**Re: Home 2 Suites – 3021 University Blvd. SE
Erosion and Sediment Control Plan
Engineer's Stamp Date 11/6/2020 Rev 11/2/2021 (M15E047)**

Based upon the information provided in your submittal received 11/2/2021, the above-referenced ESC Plan cannot be approved until after the following additional information is provided.

TEMPORARY EROSION AND SEDIMENT CONTROL PLAN

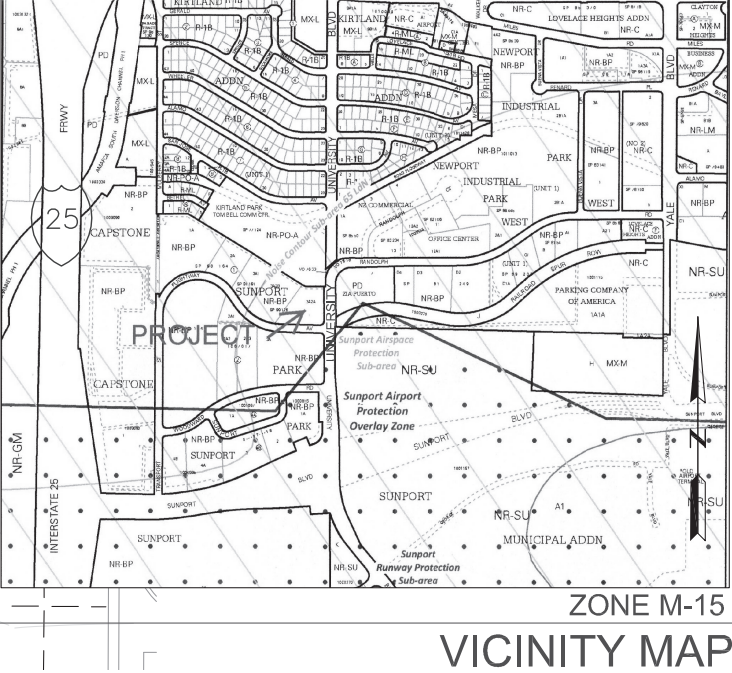
3. Show the location of the limits of land disturbing activities all of the way around the area of land-disturbing activities (CGP7.2.4.b.i).
4. Add a legend to the plan and show all BMPs including the diversion, sediment trap, silt fence, inlet protection, waste container, concrete washout, porta potty, construction entrance, and NPDES posting (CGP7.2.4.i). Both the physical location shown on a map and a narrative description of the controls is are required (CGP 7.2.6);
